To: FILE
From: Nell Donaldson
Subject: Application ID: 2014-220
Date: 12/4/2014

Memo To: Nell Donaldson
Barbara Barhydt
From: David Margolis-Pineo
Re: Review Comments for 1210 Brighton Ave - Portland Hotels 2014-220

The Department of Public Services has the follow Development Review Comments.

Sheet Title:
PAVEMENT MARKING AND SIGNAGE PLAN

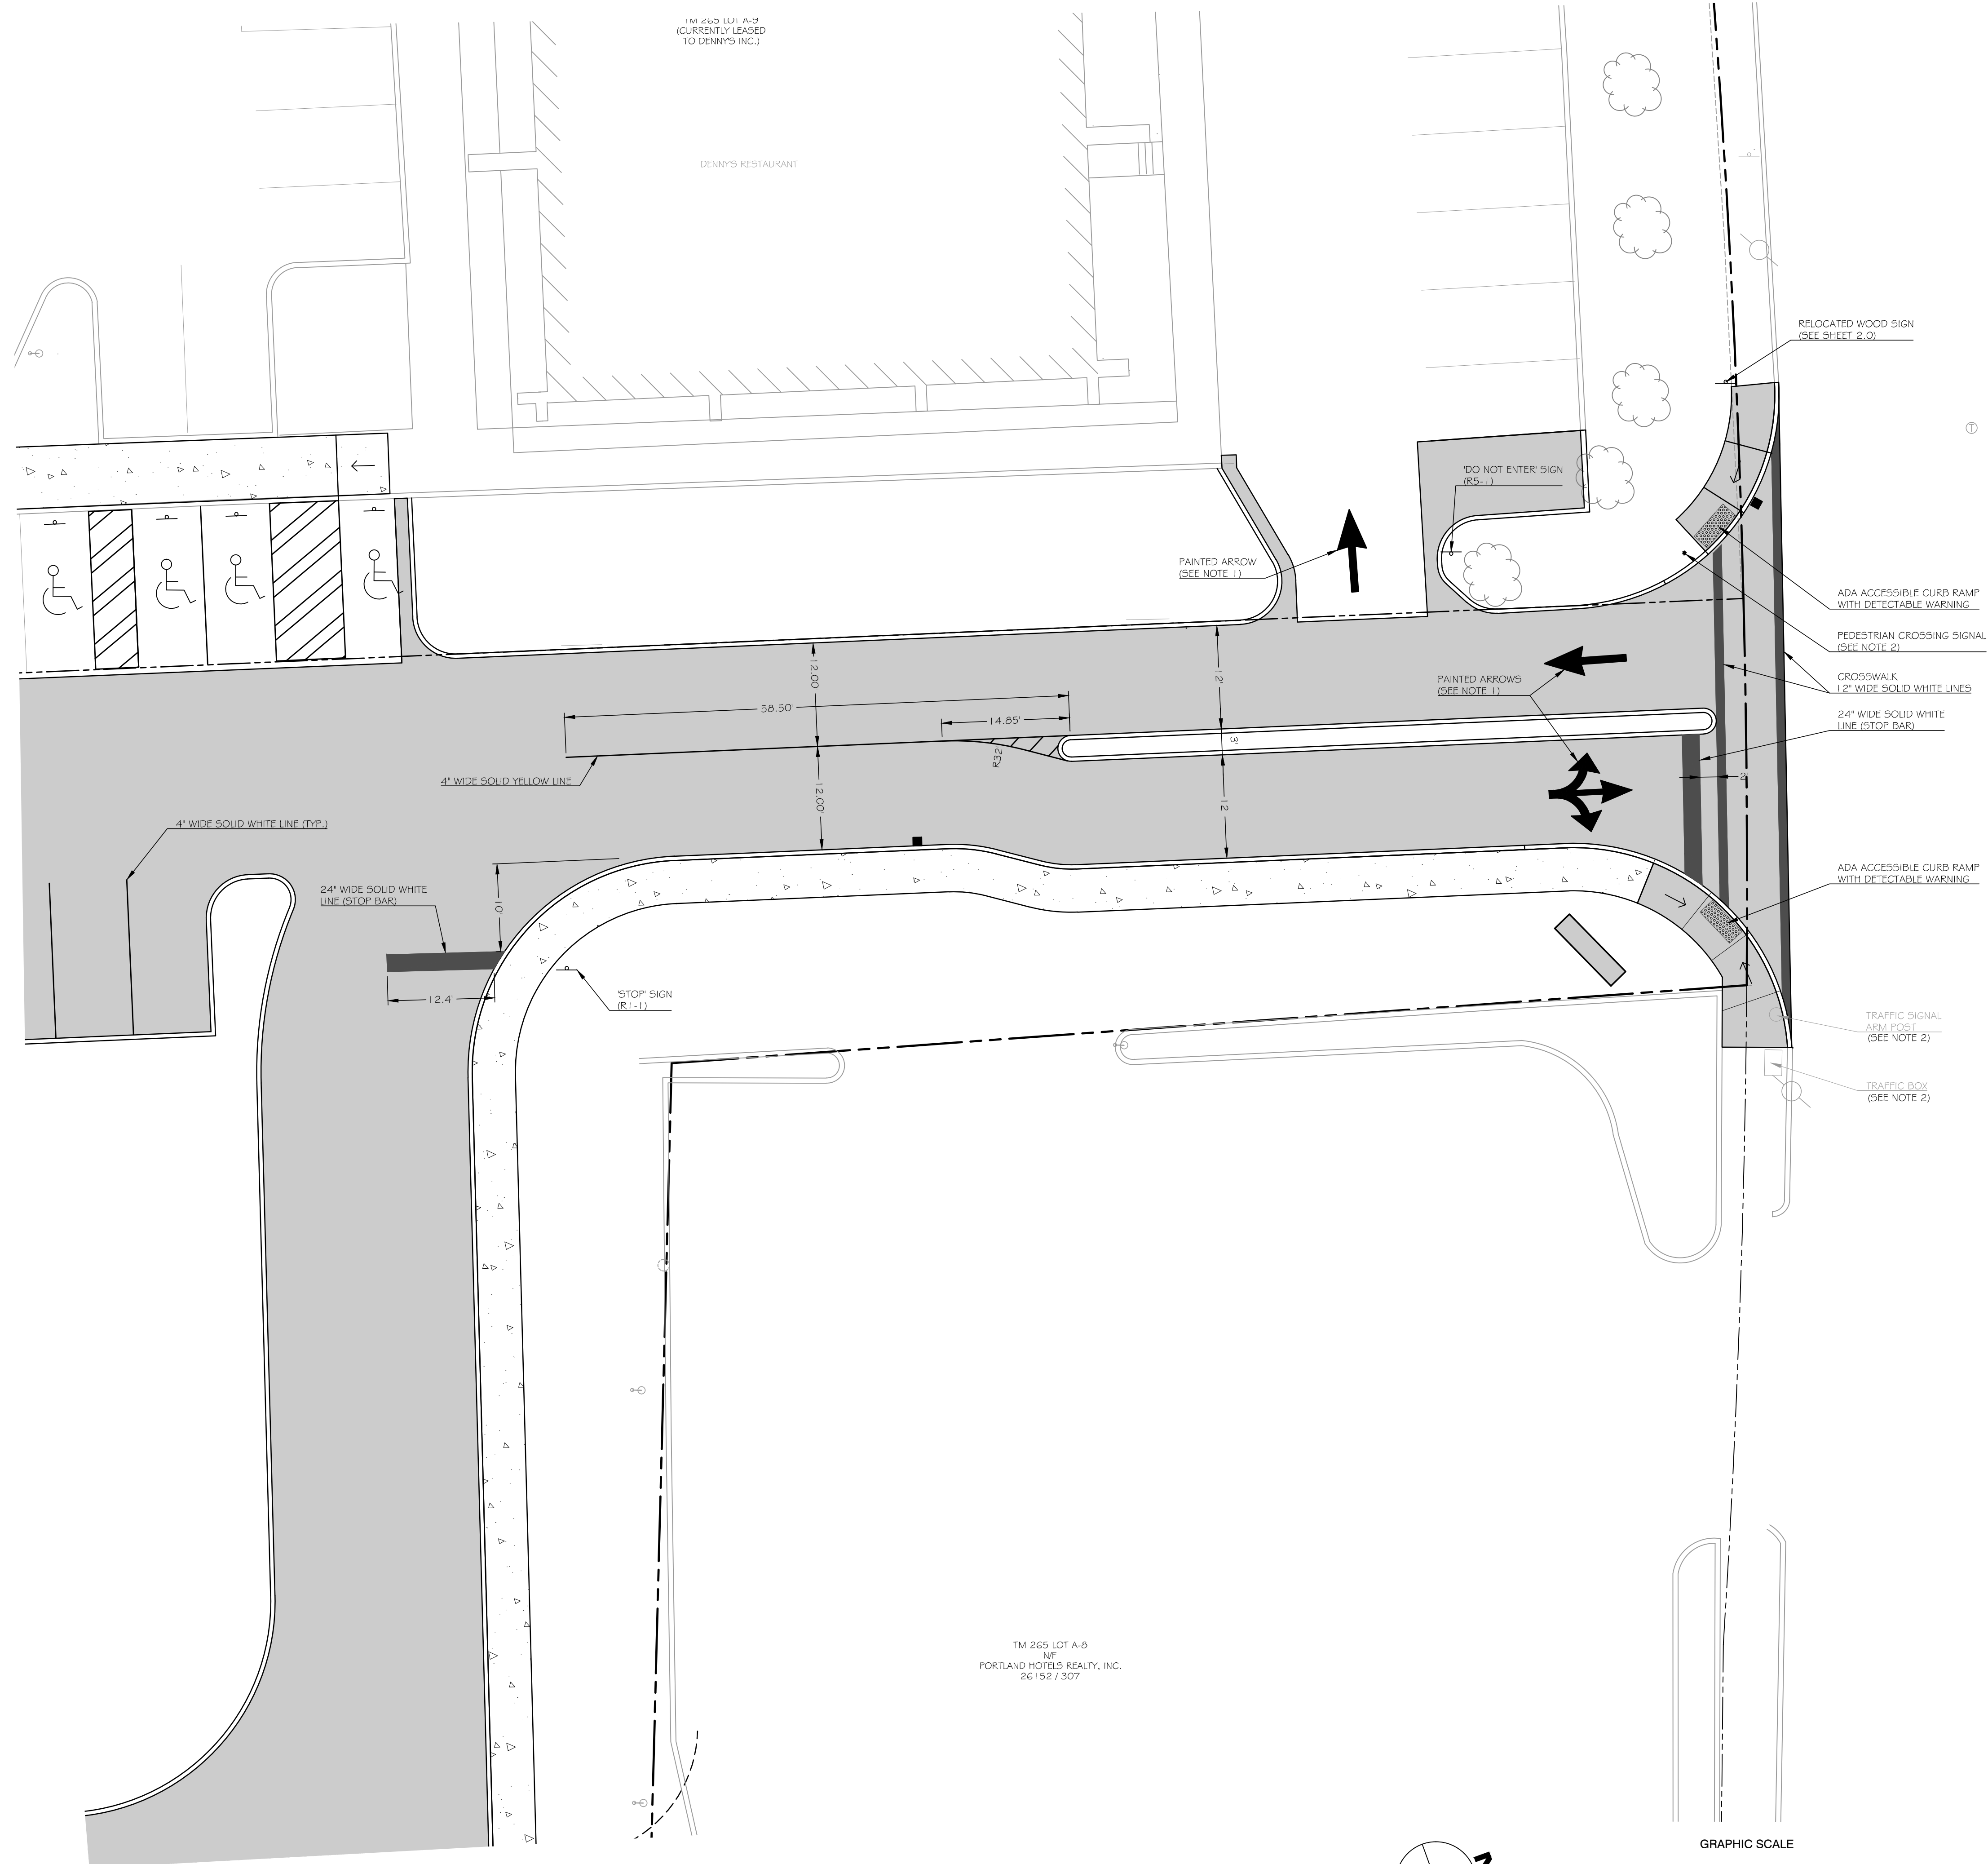
3. No sidewalk ramp or crosswalk marking are currently detailed across the drive entrance on the site plan. Please provide detail.
4. Survey comments will be forwarded in the form of a scanned pdf drawing.

Job No.:	257	Sheet No.:	
Date:	Nov. 14, 2014		<p>D1.0</p>
Scale:	1"=30'		
Drawn:	SWC		
Checked:	WRW

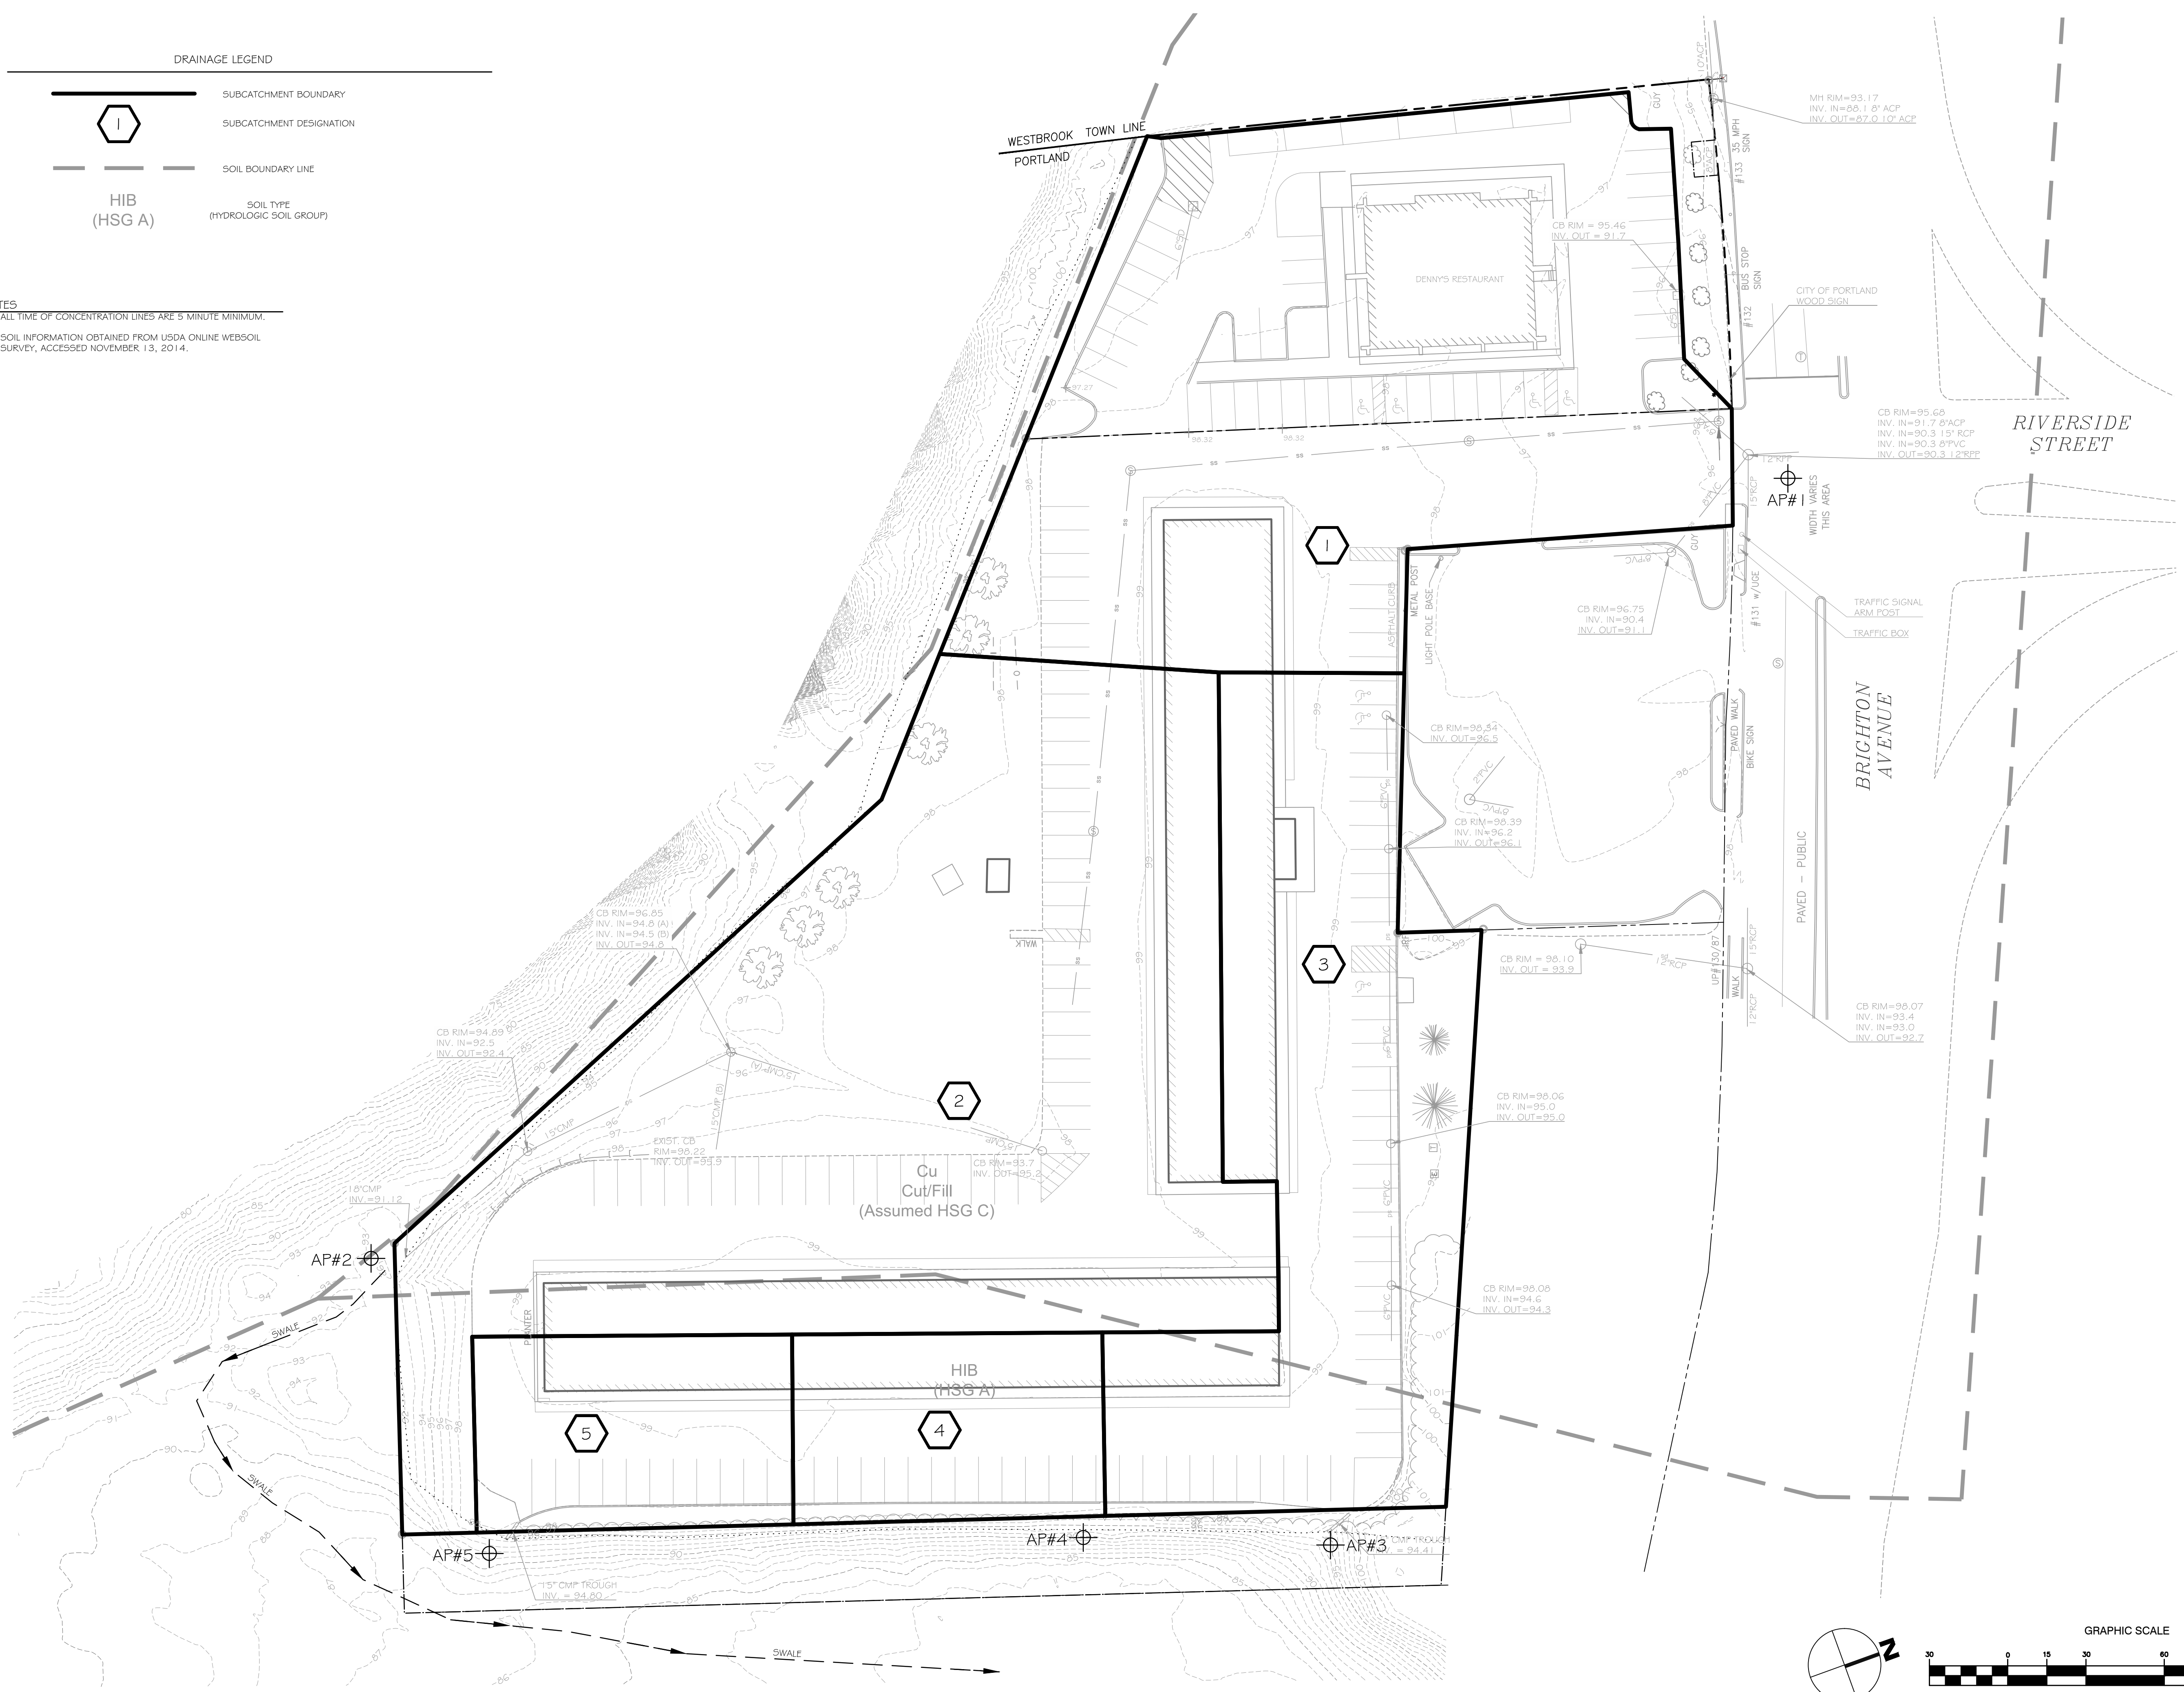
1. All proposed catch basins shall have a three foot sump per City of Portland Technical Manual standards.
2. There are several locations where site drainage is proposed to discharge on to abutting property. I am aware that the applicant is proposing to direct drainage where it already exists. Where drainage is directed towards City of Portland land the Maine Turnpike I find acceptable unless David Senu takes exception. As for the discharge onto Pike's property, I have a concern. Pike is in the process of reclaiming their pit. Once filled the intent is to redevelop this parcel. With that in mind, the applicant is requested to consider redirecting the discharge to Brighton Ave or obtain a drainage easement from Pike Industries.
